The Examining Authority's Agenda Questions June Hearings

Hearing 4

The
 ADL PROPOSED ACCESS AND EGRESS
 OFF HIGHWAYS ENGLAND SLIP LANE

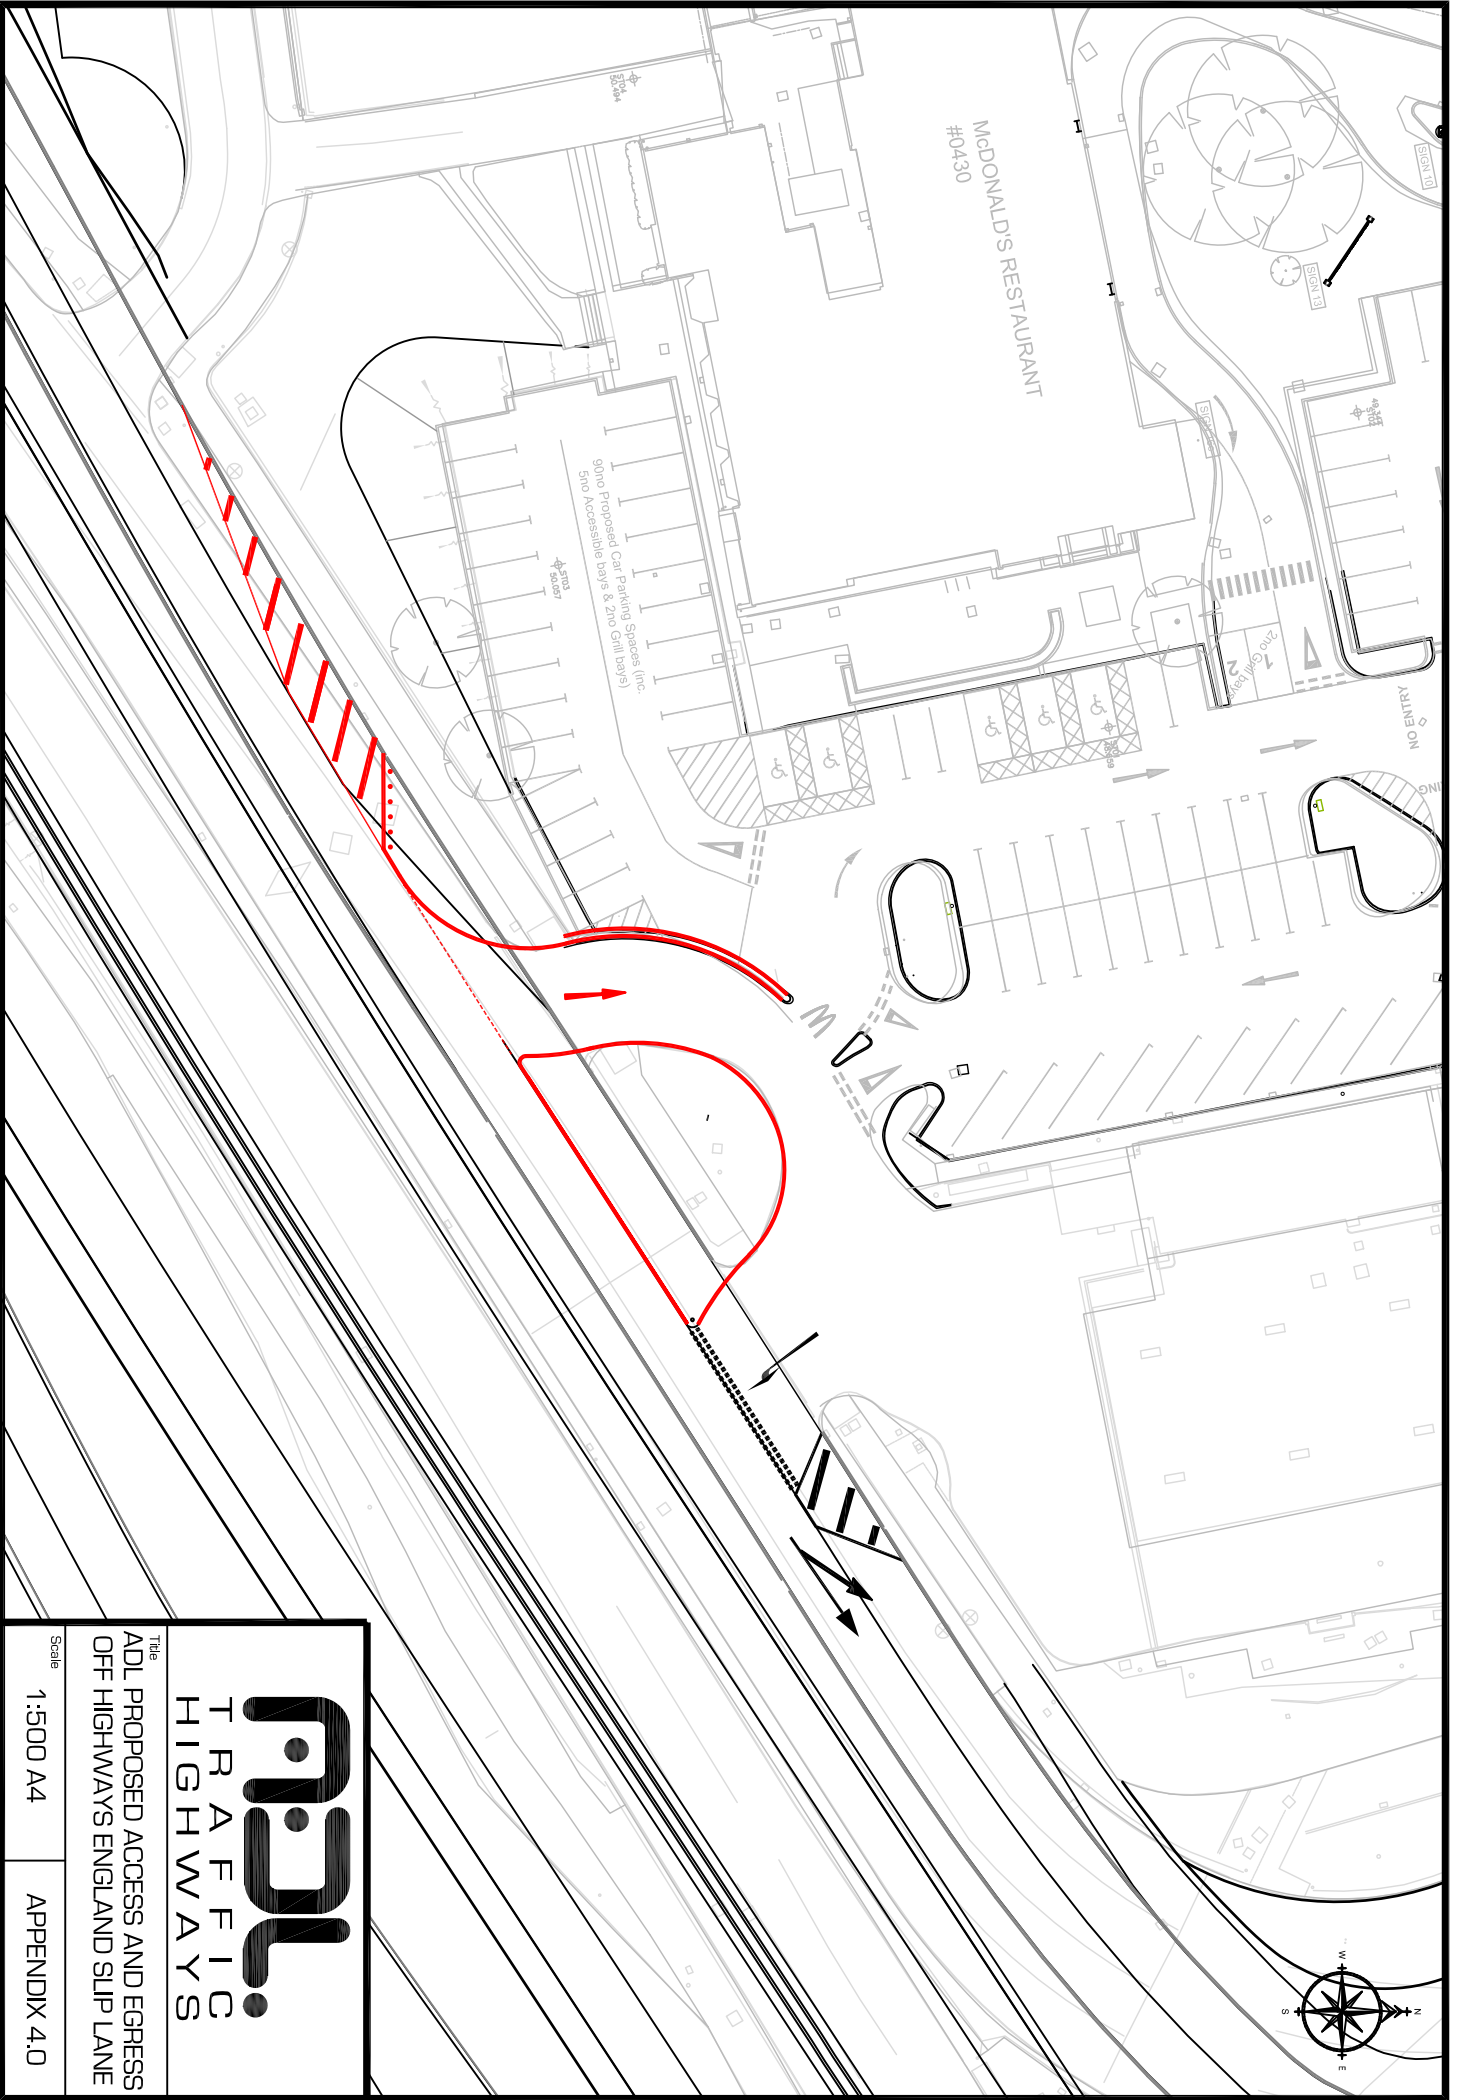
In terms of the specific access on Ashbourne Road the signals will control the movement of vehicles into and out of the Esso Garage/Mc Donald's site. From the preliminary designs provided by the applicant, DCiC is satisfied that an articulated HGV can physically turn at 10 kph into the site off the highway. The access layout is not ideal in terms of geometry and the provision for pedestrians crossing it, however, the general layout is no worse than the existing situation.
